From: [Keli Bender](#)
To: [Jeff Watson](#)
Subject: Re: BL-10-00022 Walker & SG-10-00014 Walker
Date: Thursday, June 17, 2010 3:31:23 PM

BL-10-00022 Walker & SG-10-00014 Walker

EXHIBIT

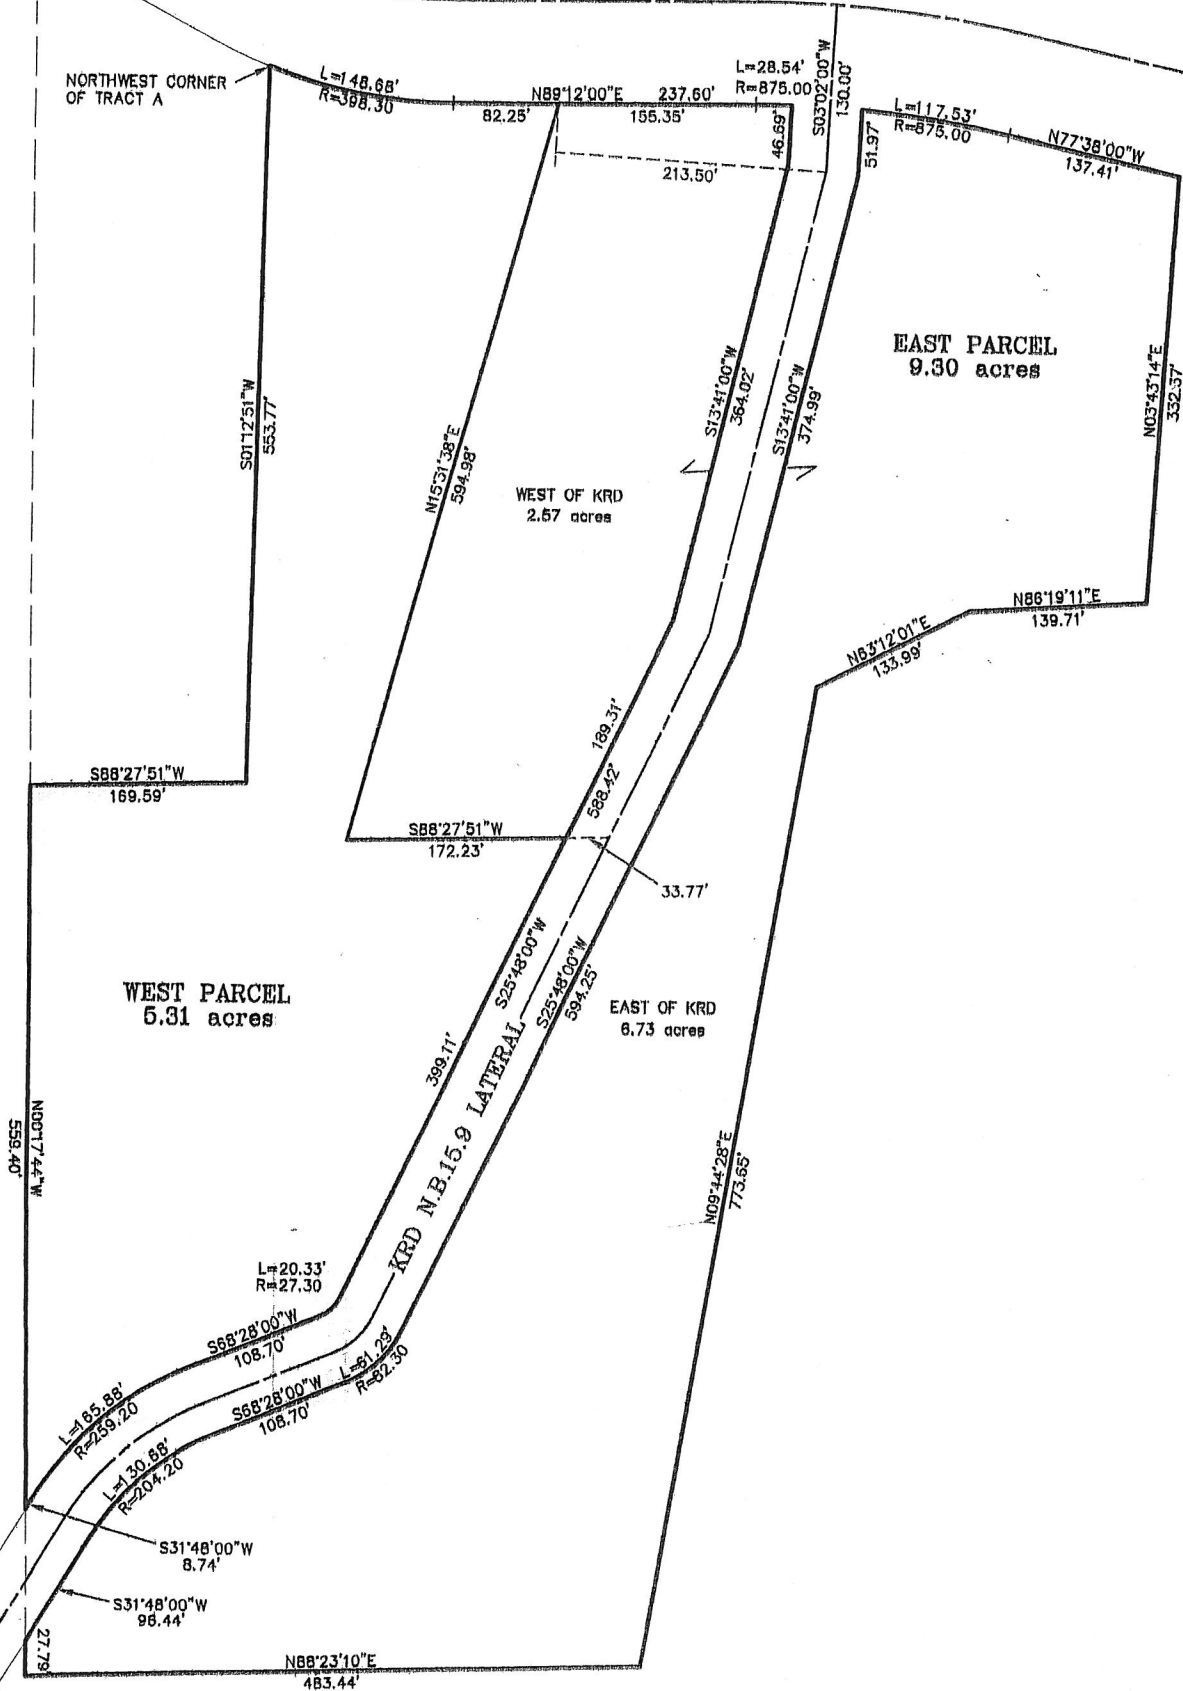
All of the KRD irrigable acres are on the parcel west of the KRD lateral. If this configuration stays, the KRD general guideline will not need to be met at all of the KRD acres will stay on that piece. If you need additional information, please let me know.
